SYDNEY OLYMPIC PARK AUTHORITY DESIGN REVIEW PANEL – ADVICE SHEET

Project	Sites 2A and 2B – Australia Ave, Sydney Olympic Park	
Presentation / Review Date	31 October 2018	
Panel Present	Ingrid Mather Caroline Pidcock Michael Harrison	JMD Design (Chair) Pidcock Architects Architectus
COI Declaration	None	
Also Present	Alix Carpenter, Ben Woods, Dylan Sargent and Catherine Modini (SOPA) Daniel West and Candice Pon (Ethos Urban) Bassam Afflak and Michael Azar (Ecove)	
Presenters	James Fitzpatrick (Fitzpatrick + Partners) Matthew Mar (Fitzpatrick + Partners) Michael Barnett (Arcadia)

SOUTH EAST ELEVATION - LOWER VIEW

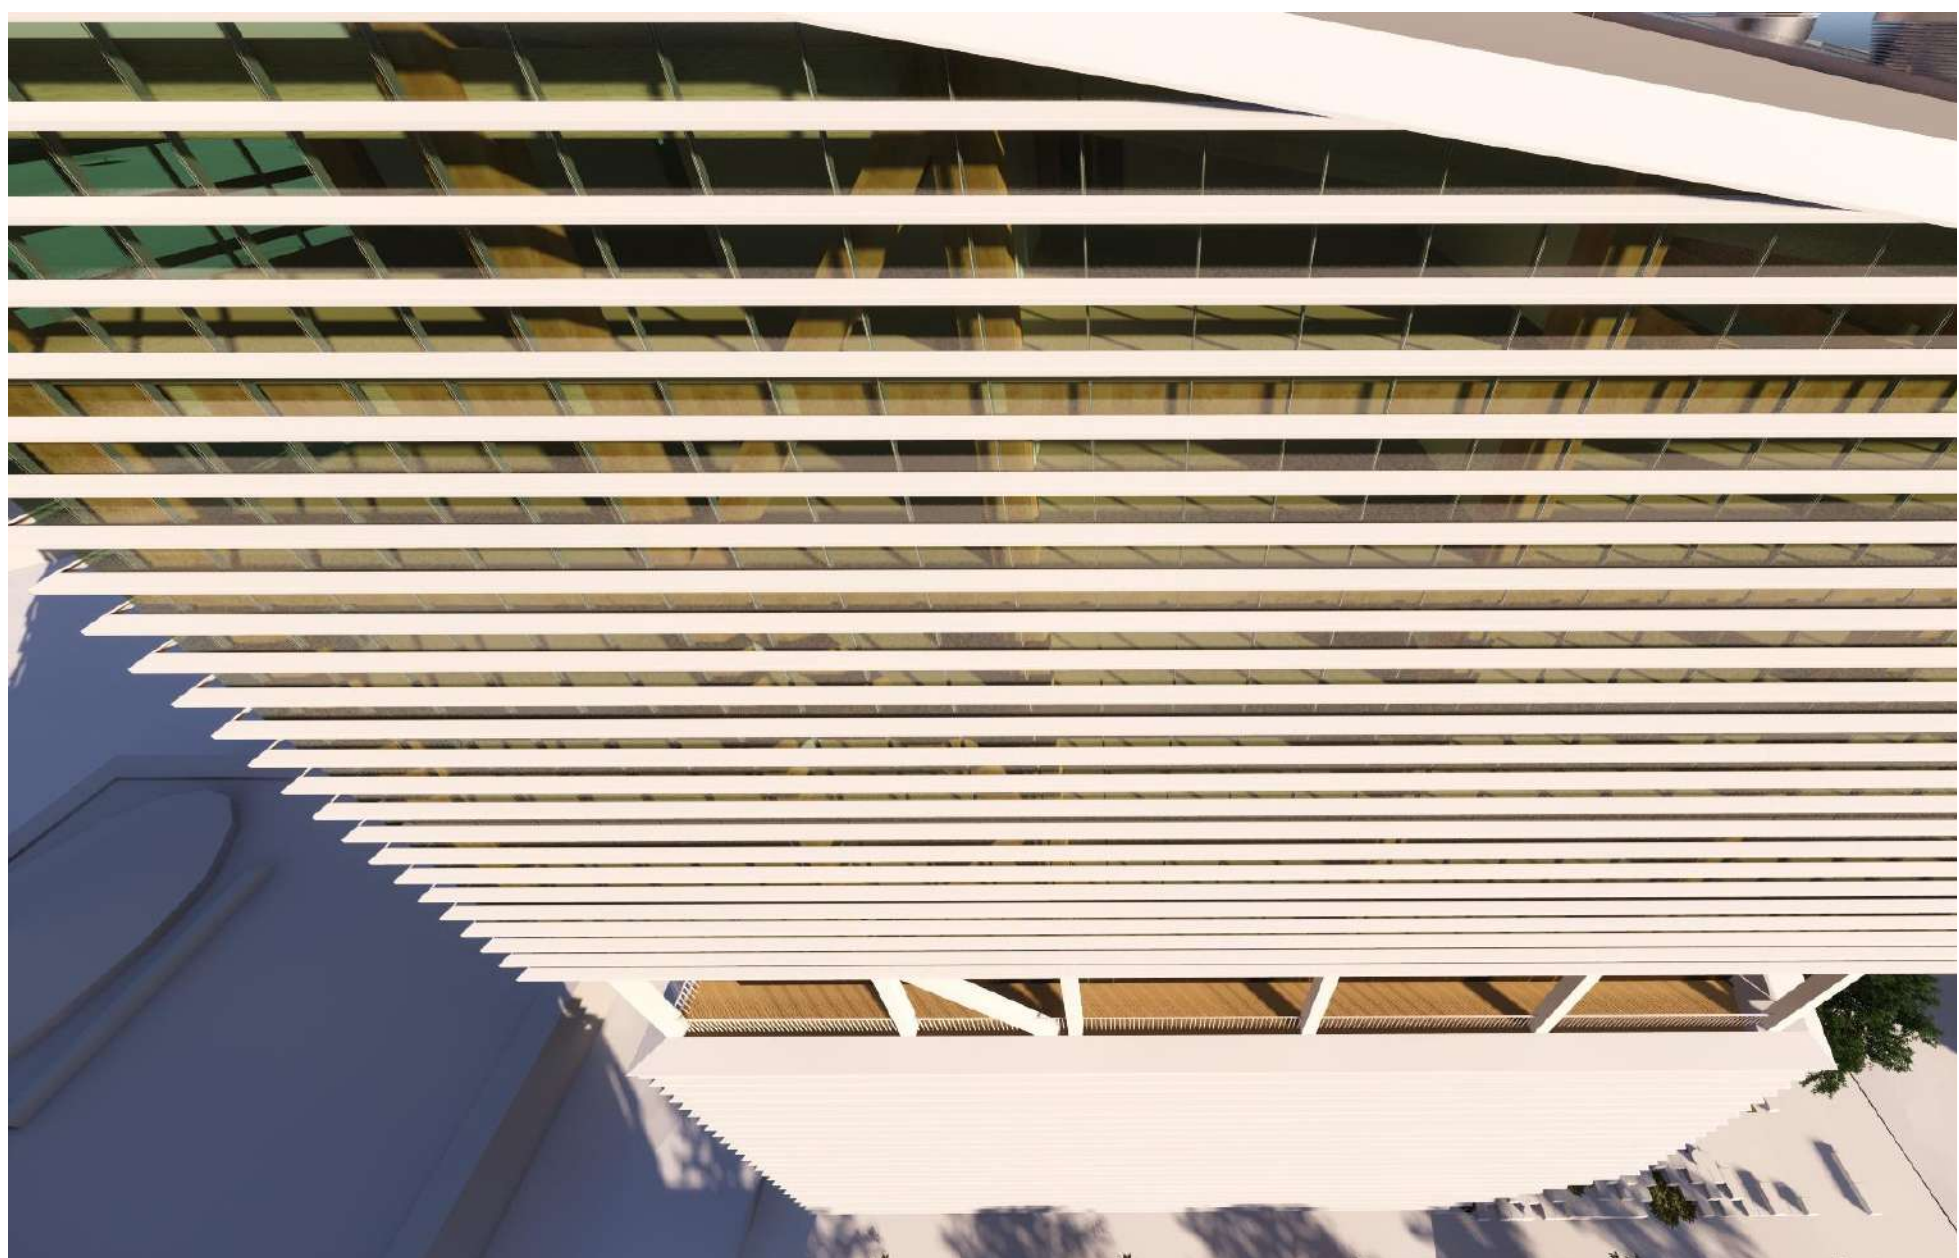
1. Façade design and solar performance:

Fitzpatrick + Partners presented a modified façade design, which included:

- a façade module around the perimeter of the tower, with equal floor to floor heights to create consistent panel geometry;
- flipping the panel geometry so that the solid triangular panels are pointed down and glass triangular panels are pointed up; and
- introduction of diagonal sunhood elements to the facades, which would vary between a consistent 150mm width on the southern facade and a tapered width of 150mm-450mm on the northern and western facades to optimise solar performance and reduce heat loading.

1. The Panel supported the design development of the façade and recommended that further development continue to be undertaken to optimise solar performance.
2. The Panel supported the decision not to include an outlook or natural lighting from lift foyers but resolved that the internal hallway design concepts needed to be further developed. In particular,

VIEW 01: SITE 2A FORECOURT

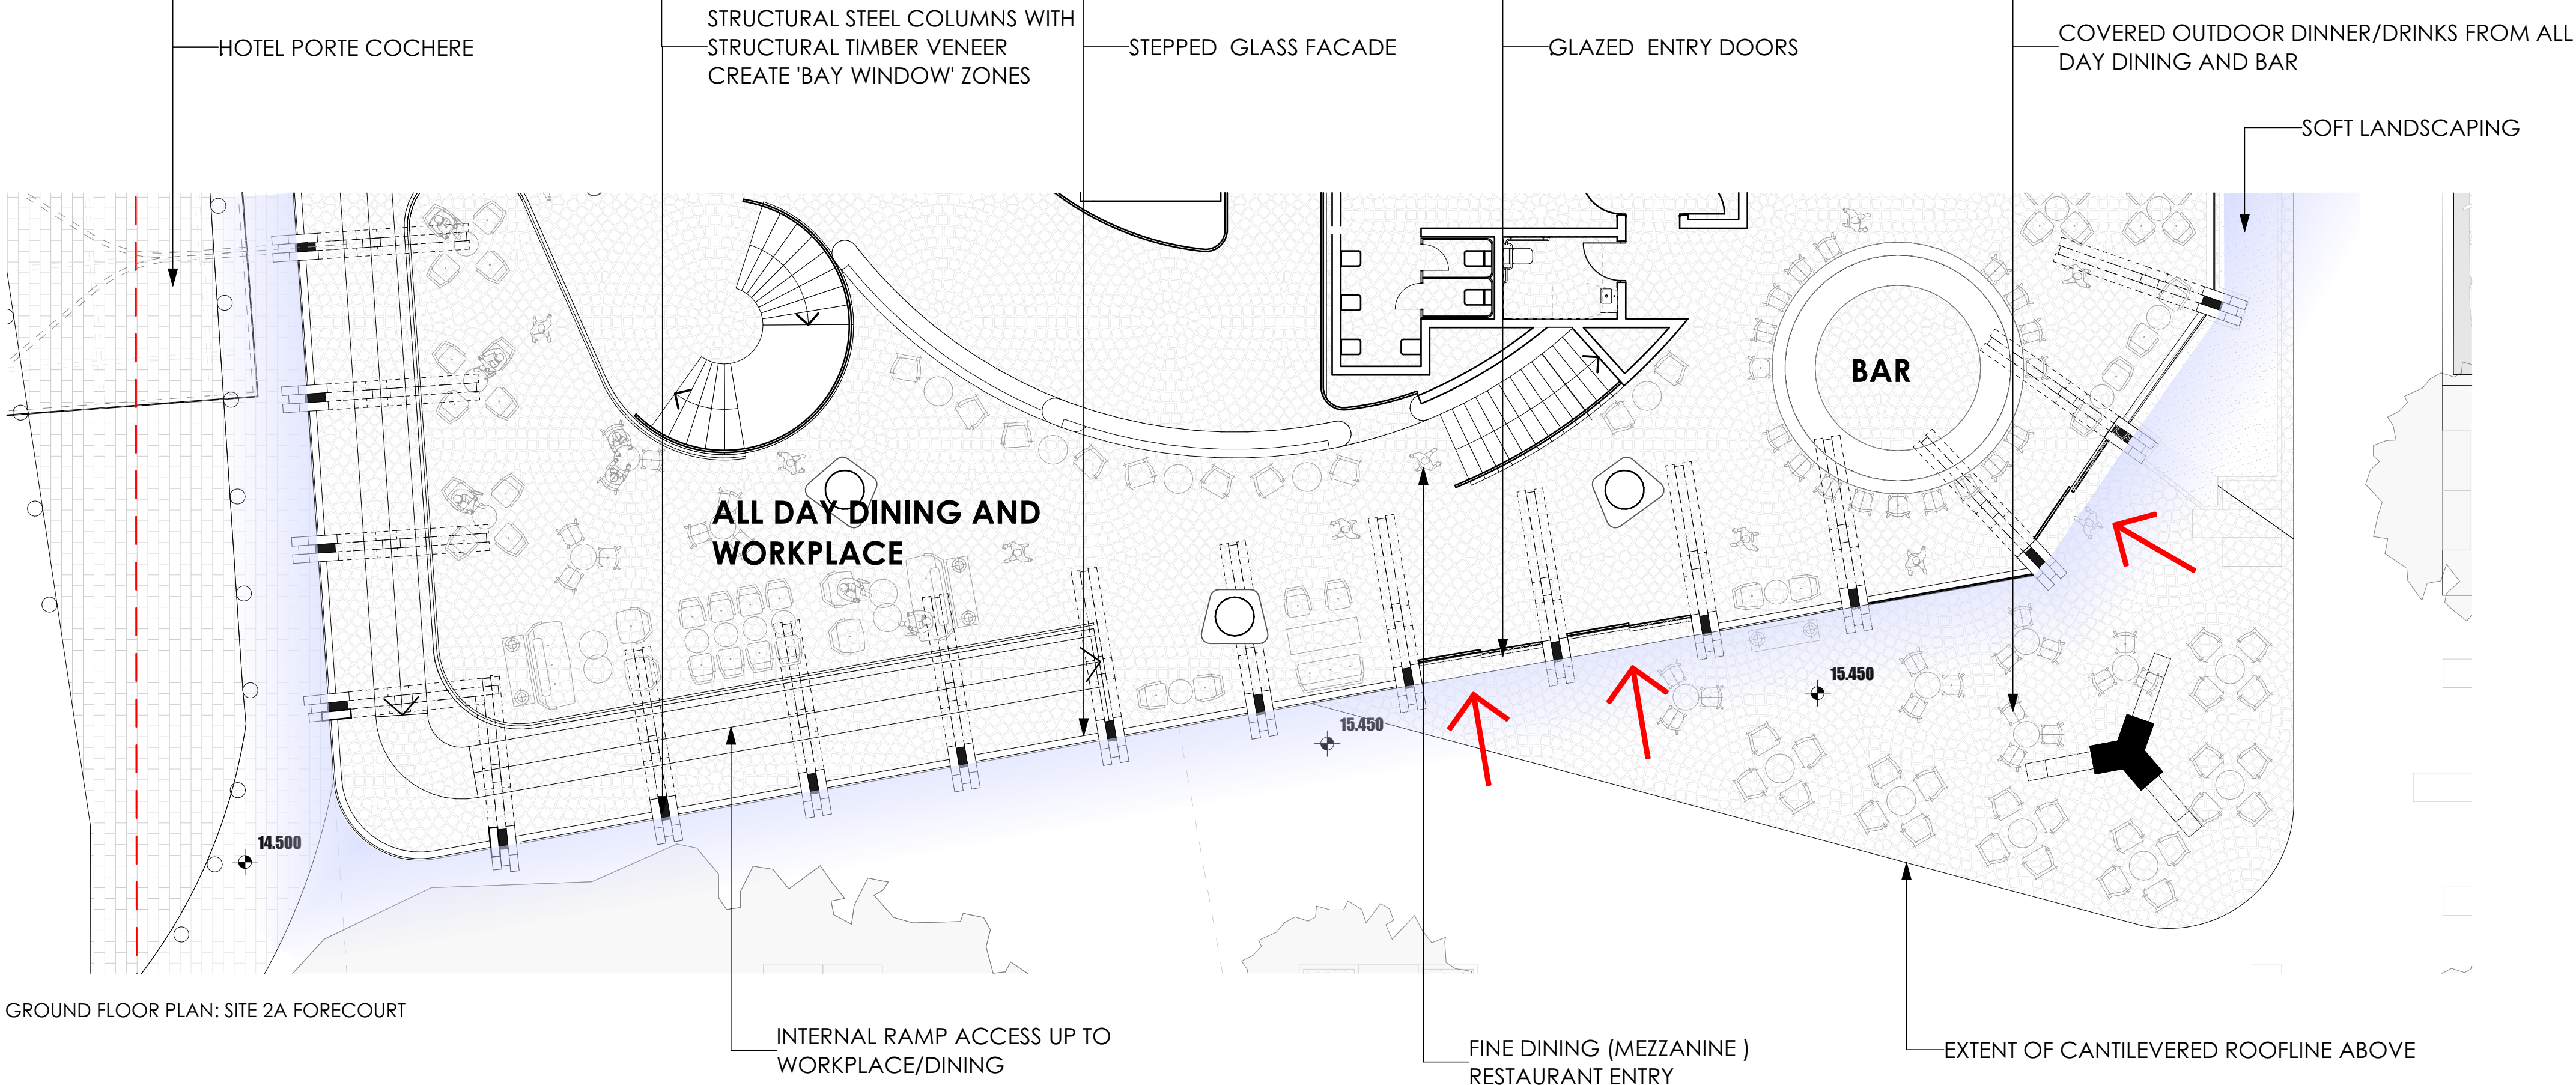
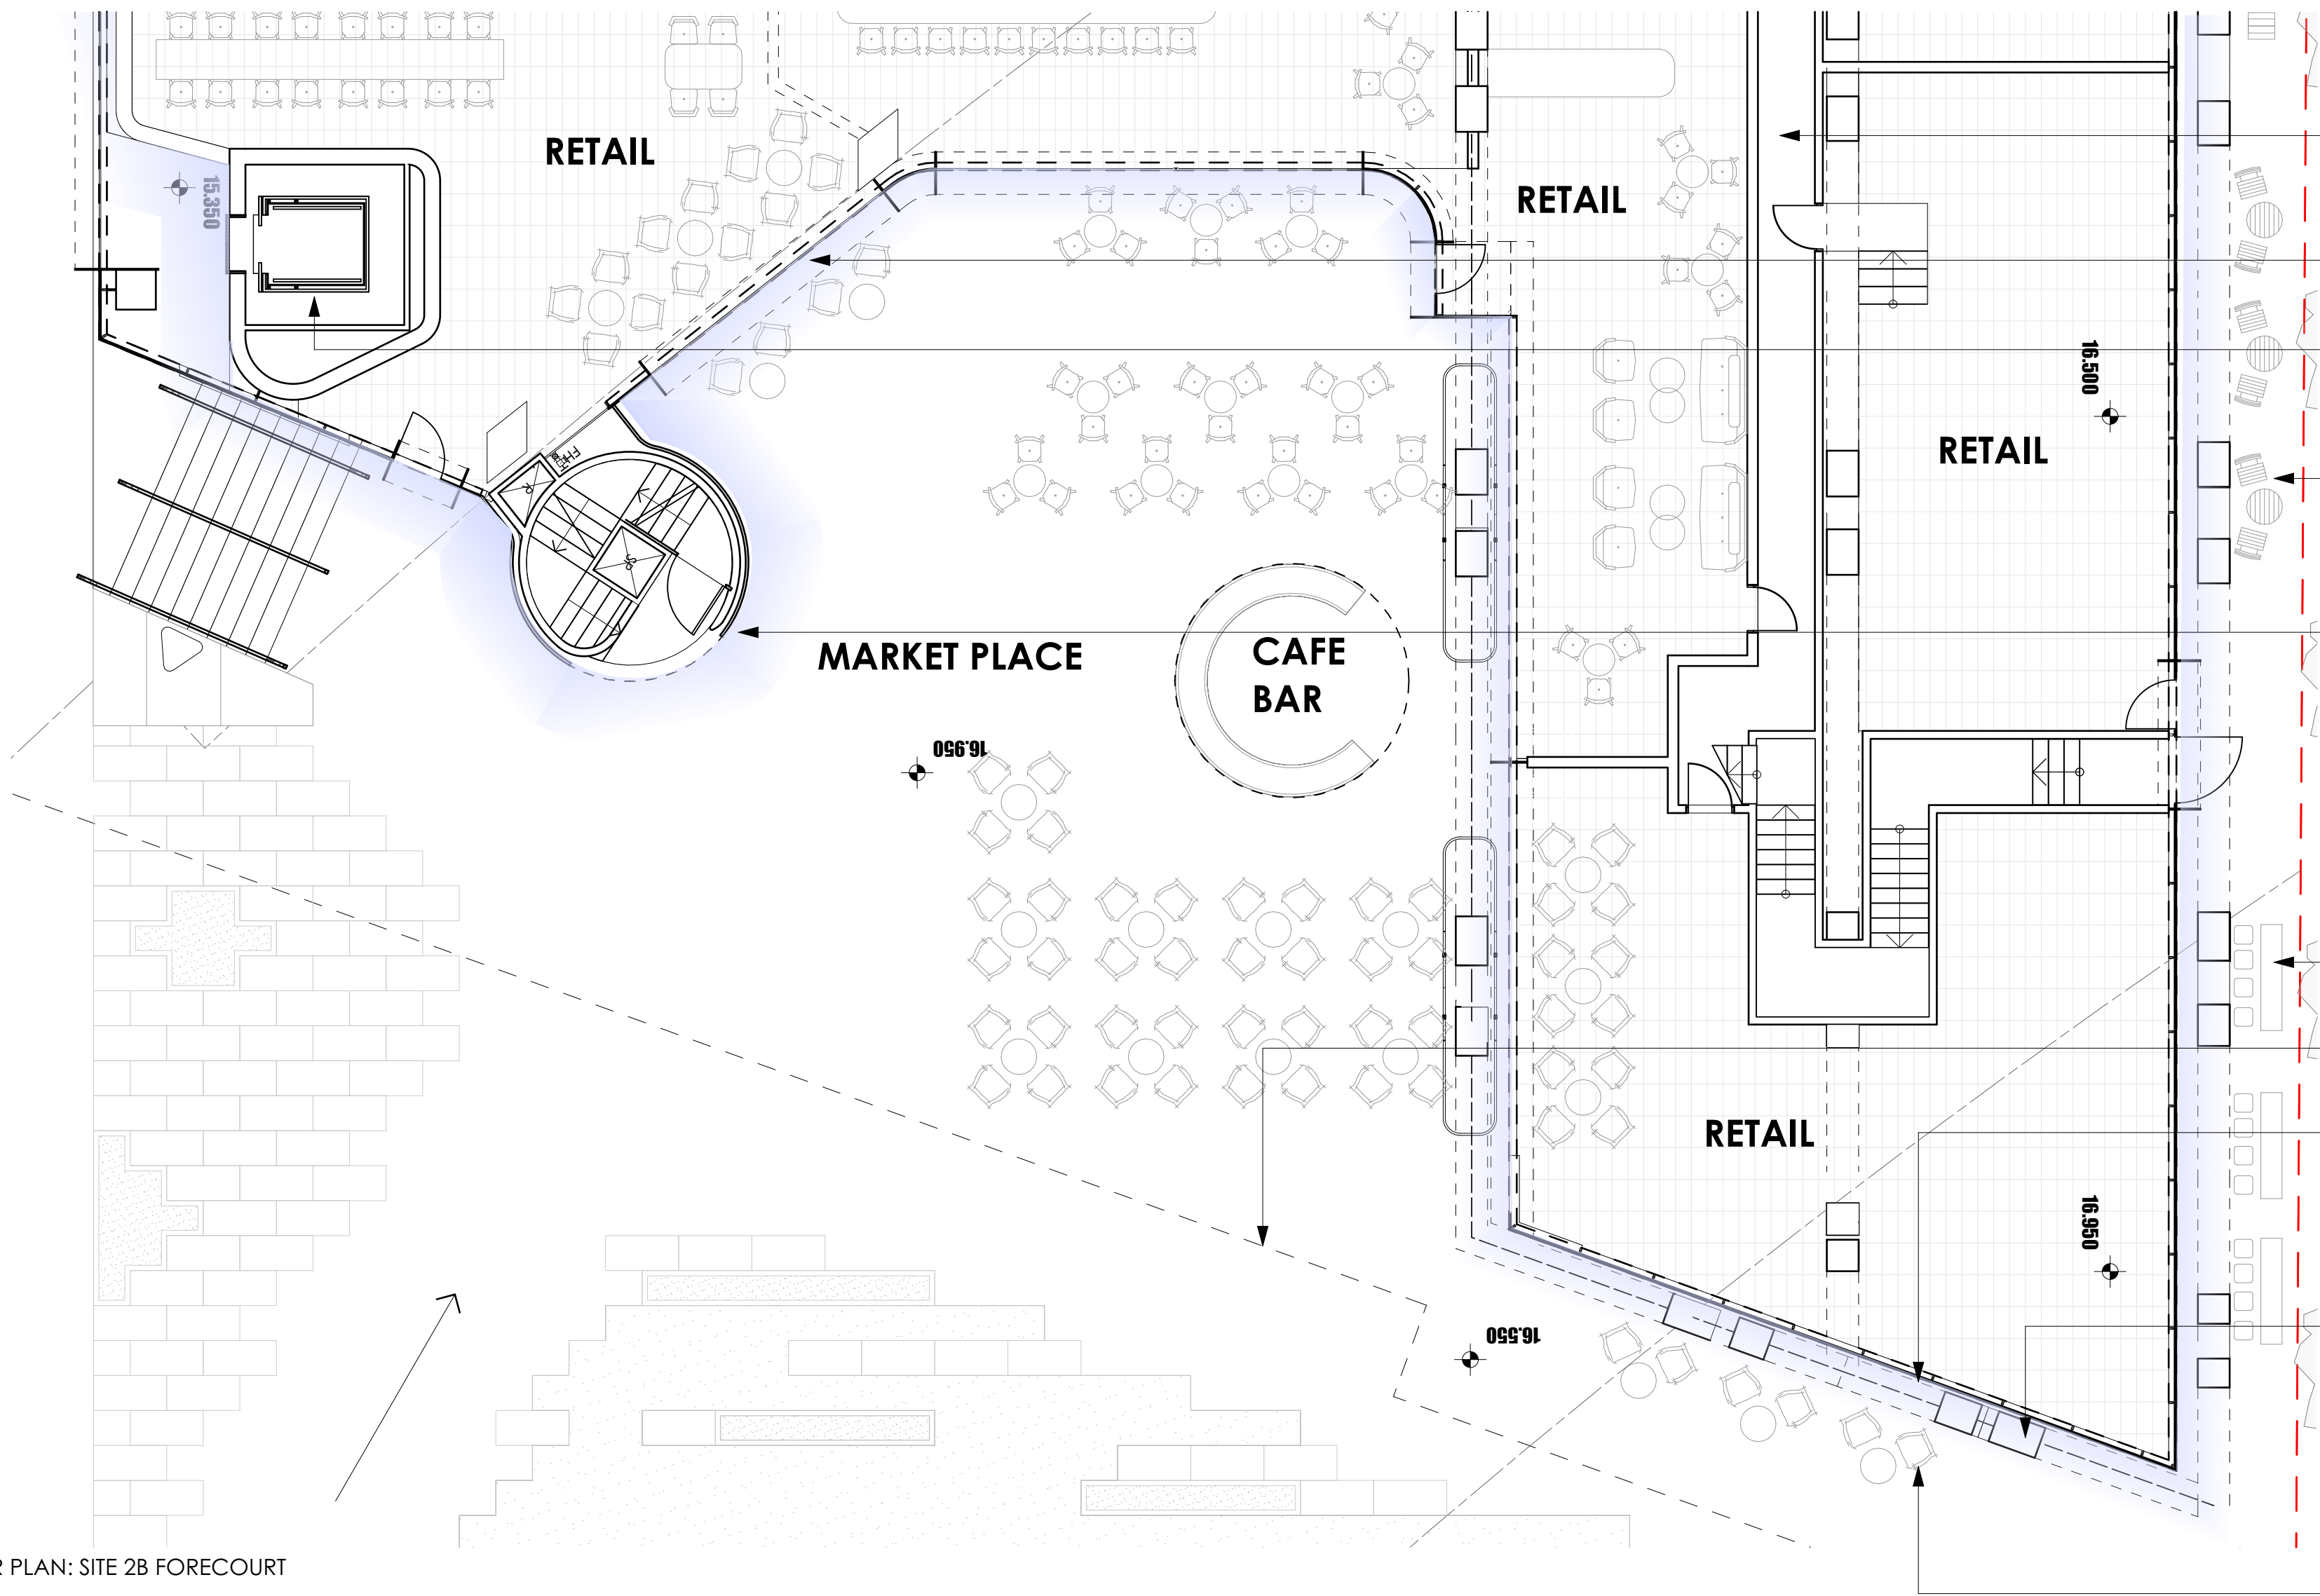
4. Public domain design:

Arcadia presented the revised public domain design, which included:

- alignment of the Dawn Fraser East extension with the Master Plan 2030 (2018 Review) layout and introduction of a turfed area at the eastern end of the street;

- stepped grass terraces from Australia Avenue to the forecourt of the building on Site 2A;
- a preferred option for the treatment of the fig tree on Site 2A involving raising the tree by 2.8m and construction of timber decking around the buttress roots;

- extension of the outdoor dining areas of market hall at ground level of the building on Site 2B towards the new road; and
- locating a misting sculpture to evoke mangrove aerial roots near the entrance to the lobby of the building on Site 2A.

4. The Panel resolved that the public domain concepts are not adequately resolved. Further development of the design is required and needs to consider the following:

- a. Future-proofing the Dawn Fraser East extension to allow it to function as a shared zone or road extension as development to the east of the site occurs;

- b. Creating a stronger nexus between each building and the surrounding ground plane design and spaces for public use;
 - c. The response to the forecourt of the market hall at Site 2B, so as to reduce clutter and barriers to movement;

- d. How the public domain responds to the surrounding streetscapes including accommodating service access and how internal circulation will occur;
 - e. Resolution of the porte cochere design with regard to levels, treatments, interaction with the footpath, sight lines and queuing areas;

- g. Appropriate locations for turf and soft landscaping to maximise its use and minimise risk of failure from overshadowing and foot traffic

The Panel had concerns about the resolution of levels between the public domain, buildings and the surrounding road network across the entire site but acknowledged that this issue could be further developed through the SSD application and post-approval process if the overall landscape concept was improved. The Panel also recommended that a wind analysis be undertaken for the ground plane.
